CITY OF ALBUQUERQUE

November 29, 2021

Re: Copper Terrace Bldg A
12801 Copper Ave. NE
Traffic Circulation Layout
Architect's Stamp 11-16-2021 (K22-D062)

sheet no:  
 TCL1.0

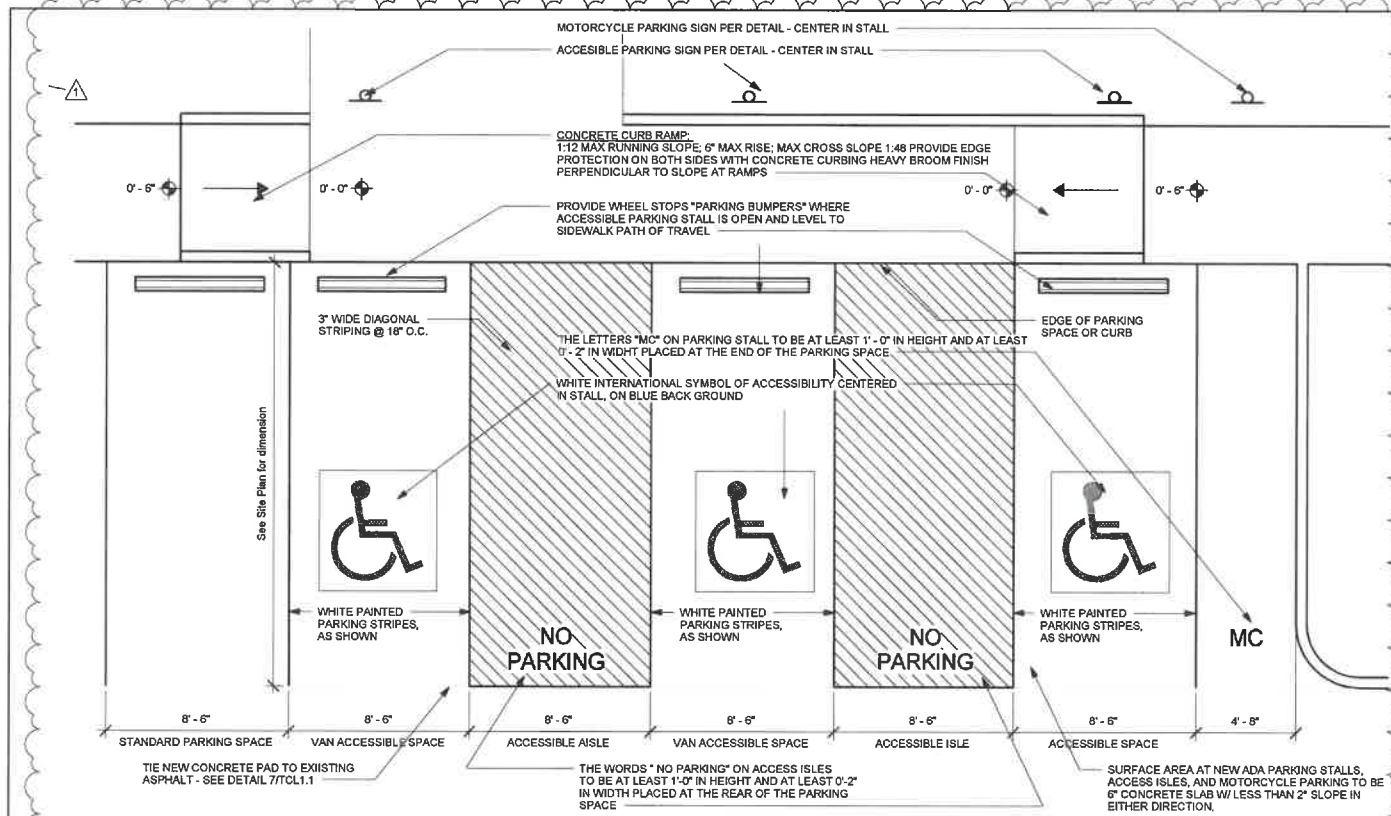
- Provide missing keyed notes 17 & 22.
- Keyed Note 1: Details need to be provided.
- Keyed Note 3: details for pavement marking (MC) and sign face detail needs to be provided.
- Keyed Note 5: Explain the sidewalk segment in front of ADA stalls and access aisle, flush to pavement elevation? If so, then provide note specifying this condition.
- Keyed Note 8: Provide width.

2. All proposed striping, pavement markings, and signage (sign face) will need details. Show ADA signage location and make sure it doesn't interfere (reduced the ADA 6 ft wide pedestrian pathway from access aisle to building entrance)

3. The ADA accessible spaces must include an access aisle. Van accessible aisles should be 8ft wide; all others should be 5ft wide. Provide dimensions for access aisles

4. ADA parking stalls will need parking bumpers (provide detail) to avoid reducing sidewalk width requirement for ADA 6 ft wide pedestrian pathway.
5. The ADA accessible parking sign must have the required language per 66-7-352.4C NMSA 1978 **"Violators Are Subject to a Fine and/or Towing."** Please call out detail and location of signs.

6. The ADA access aisles shall have the words **"NO PARKING"** in capital letters, each of which shall be at least one foot high and at least two inches wide, placed at the rear of the parking space so as to be close to where an adjacent vehicle's rear tire would be placed. (66-1-4.1.B NMSA 1978)

9. A 5 ft. keyway is required for dead-end parking aisles.
 10. Per DPM, a 6 ft. wide ADA accessible pedestrian pathway is required from the ADA parking stall access aisles to the building entrances. Please clearly show this pathway and provide details.

11. Per the DPM, a 6 ft. wide ADA accessible pedestrian pathway is required from the public sidewalk to the building entrances. Please clearly show this pathway and provide details or has it been provided by existing sidewalk (Keyed Note 4).

12. Keyed Note 4: Provide sidewalk width.

- Please provide a sight distance exhibit at entrance.
 - Show the clear sight triangle and add the following note to the plan:
"Landscaping and signage will not interfere with clear sight requirements. Therefore, signs, walls, trees, and shrubbery between 3 and 8 feet tall (as measured from the gutter pan) will not be acceptable in the clear sight triangle."
13. Please specify the City Standard Drawing Number when applicable.
 14. Add a note stating "All broken or cracked sidewalk must be replaced with sidewalk and curb & gutter." A build note must be provided referring to the appropriate City Standard drawing (2430 & 2415A).
 15. Please provide a letter of response for all comments given.

5 Motorcyle Parking Signage  
3/4" = 1'-0"

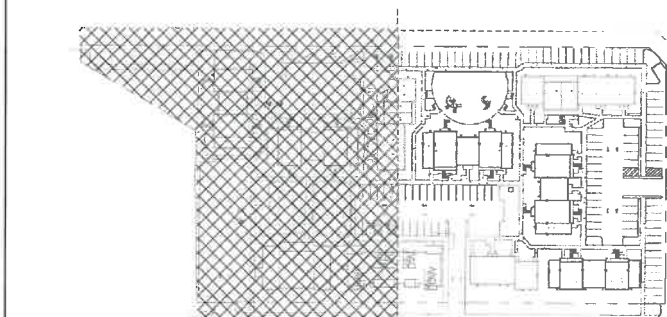
- Keyed Note 7: Ramp will need detail and/or reference COA std dwg 2443.
8. Motorcycle parking spaces shall be designated by its own conspicuously posted upright sign, either free-standing or wall mounted per the zoning code. Label pavement MC. Detail will need to be provided.

8 Curb Ramp Detail 2  
1/4" = 1'-0"

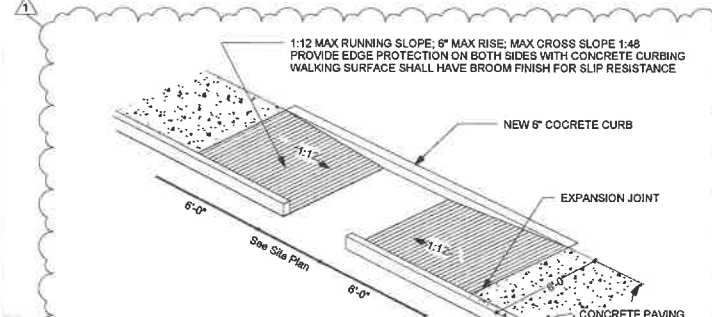
7. ADA curb ramps:
 - Ramps must be updated to current standards and have truncated domes installed.

- Copper entrance will need to service multi-directional and it appears that ramp doesn't service sidewalk connection onto site (Shown on site plan). Modify existing ramp and provide detail and/or reference COA std dwg 2441.
